CITY OF ALBUQUERQUE

December 20, 2018

**Re: Winfield TI,
7501 Meridian Pl. NW Suite B-1
Request for Certificate of Occupancy
Transportation Development Final Inspection
Engineer's/Architect's Stamp dated 9-05-18 (K10D023G)
Certification dated 10-31-18**

4 HANDICAP PARKING SIGN  
1"=1'-0"

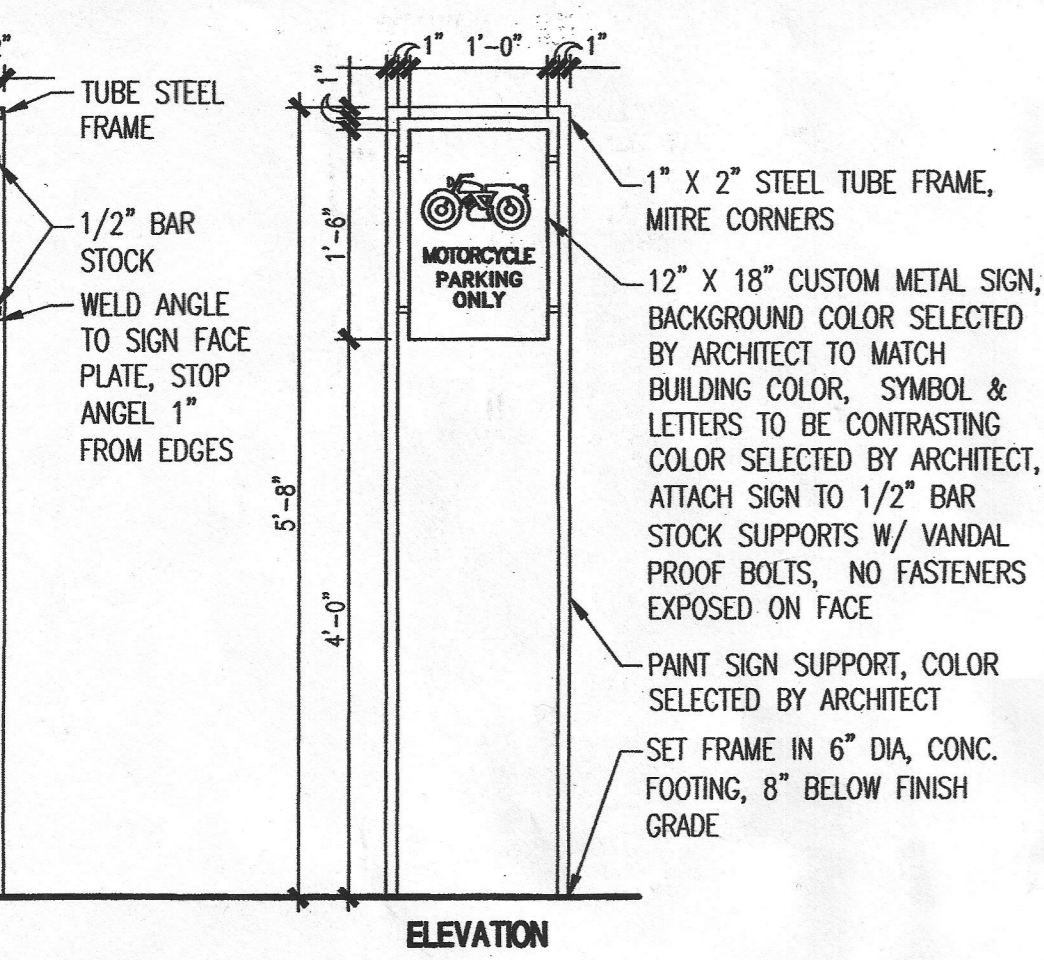
1. The ADA accessible parking sign must have the required language per 66-7-352.4C NMSA 1978 **"Violators Are Subject to a Fine and/or Towing."**
